EL PASO COUNTY STORMWATER MANAGEMENT PLAN CHECKLIST

Revised 5/21/07

GRADING & EROSION CONTROL PLAN

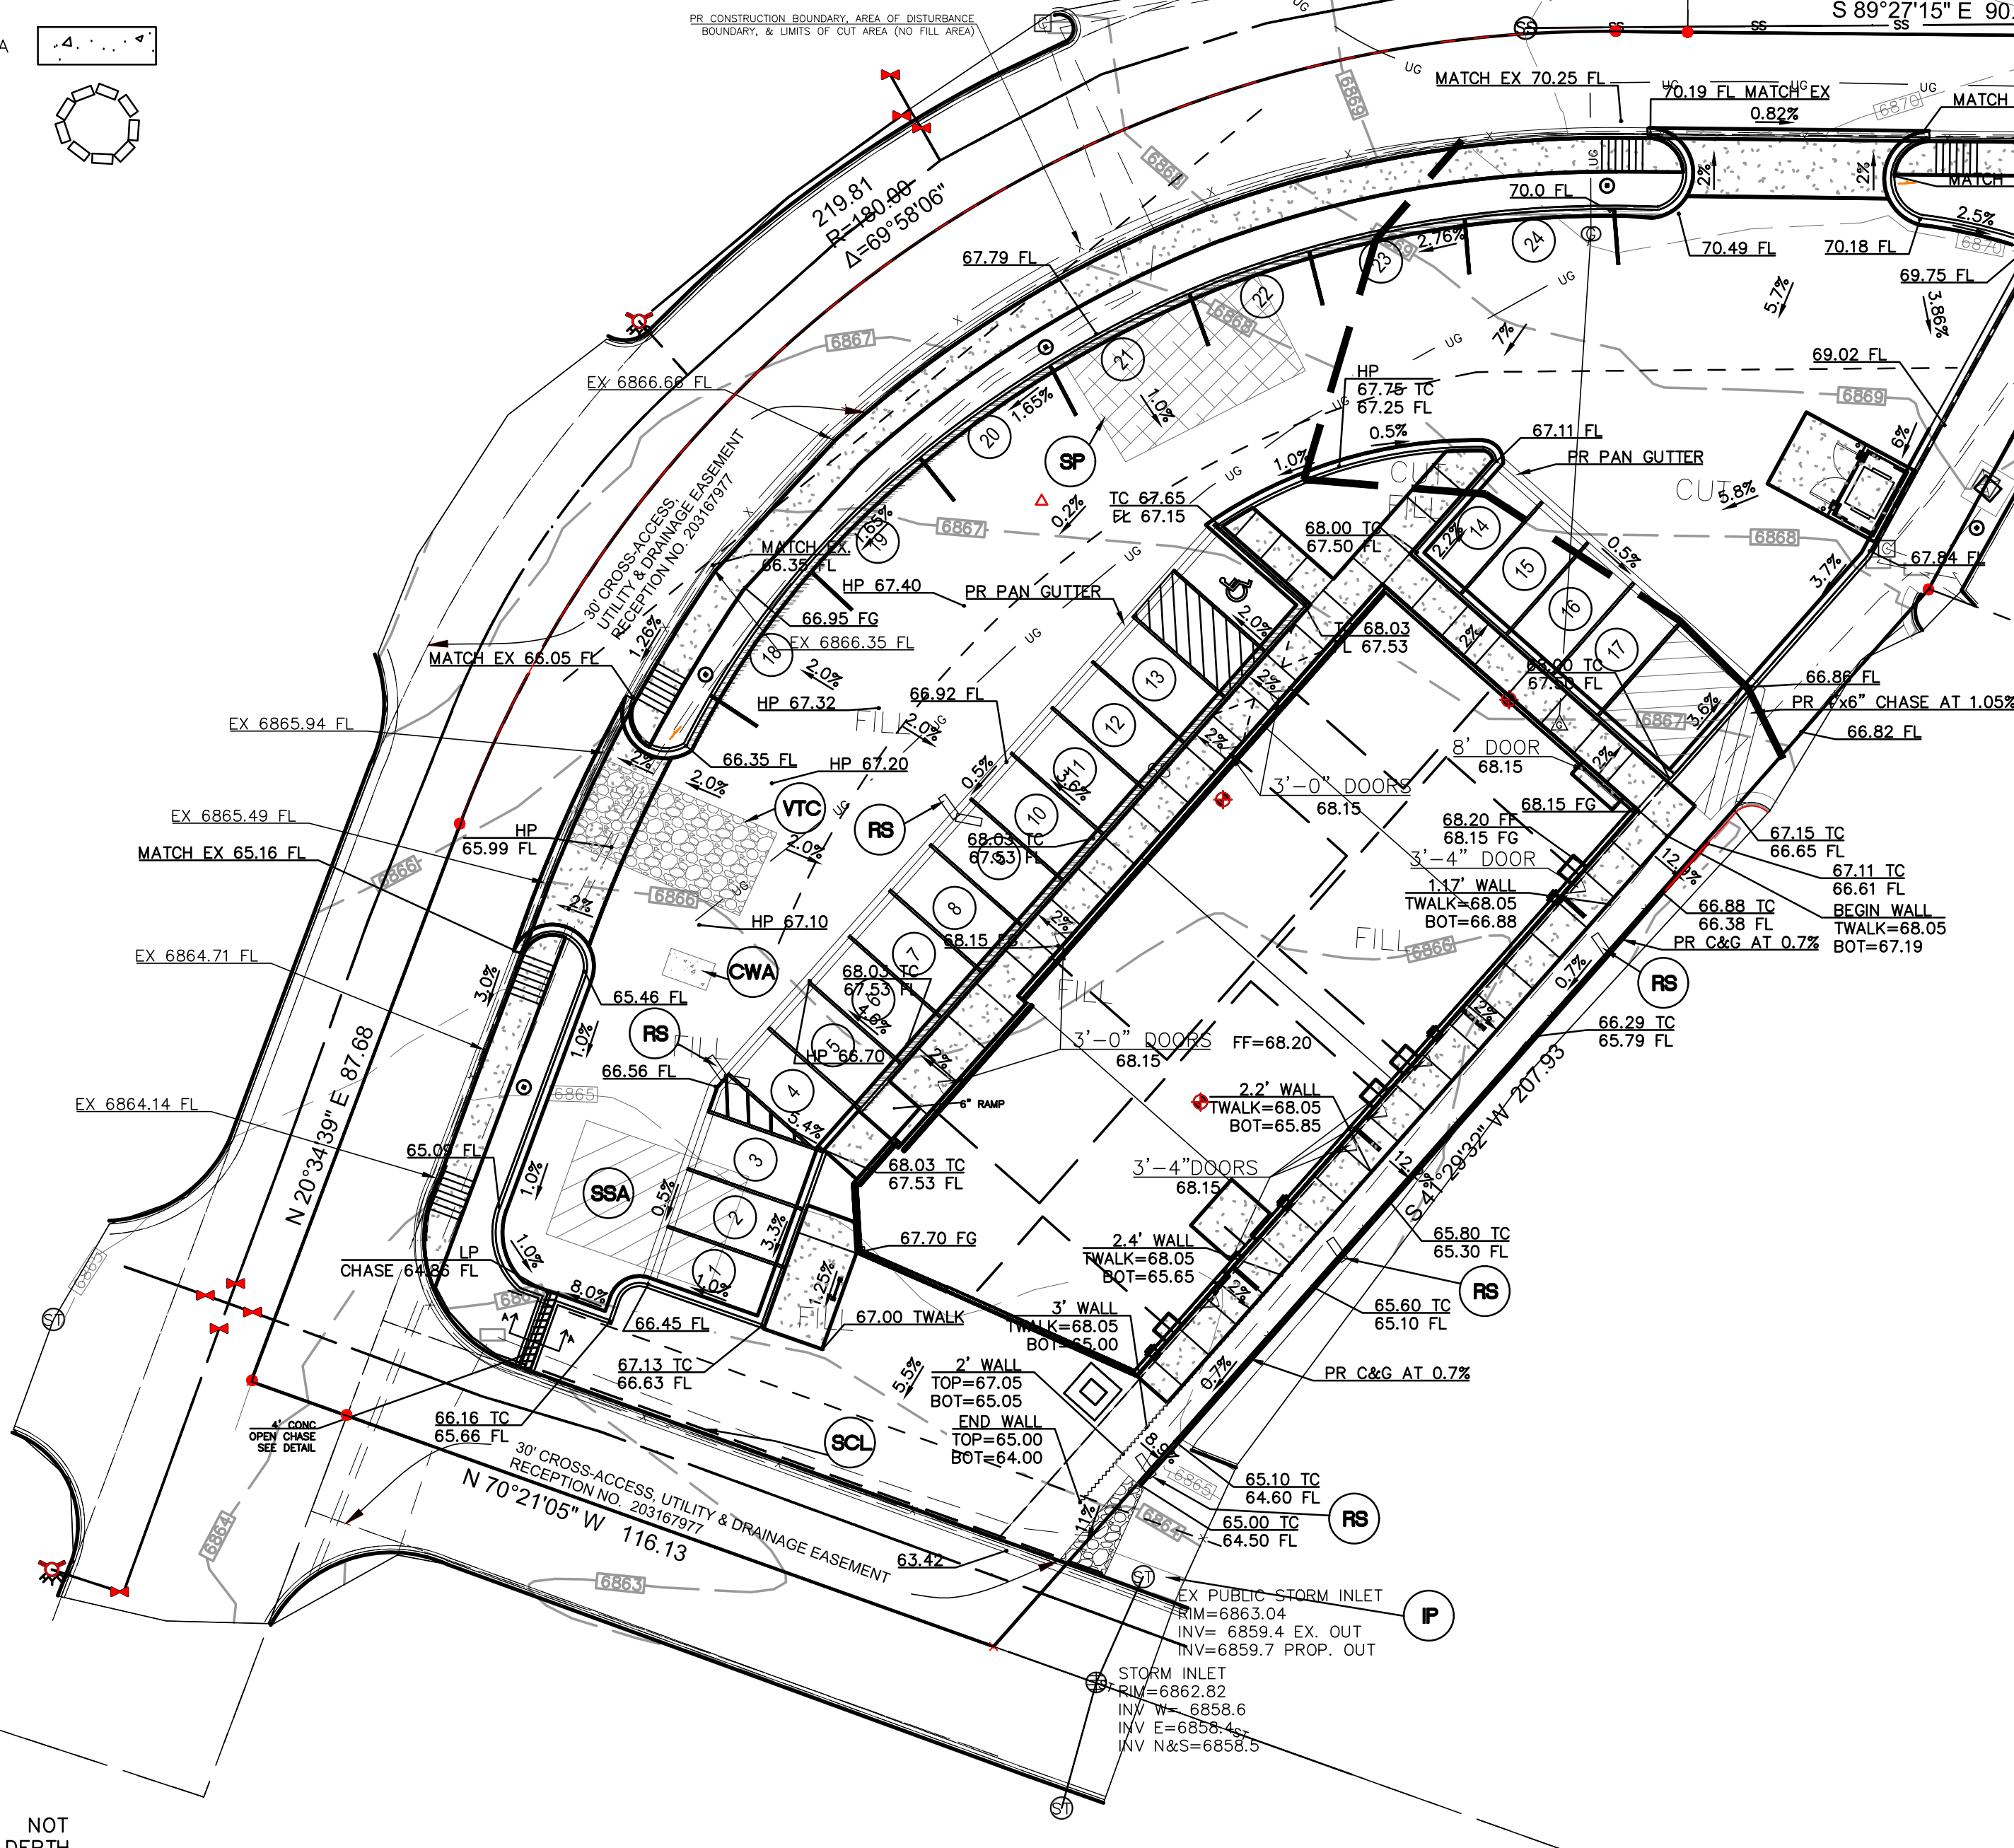
Unresolved
01/11/2018

Unresolved
06/19/2018

Was not included in the submittal.
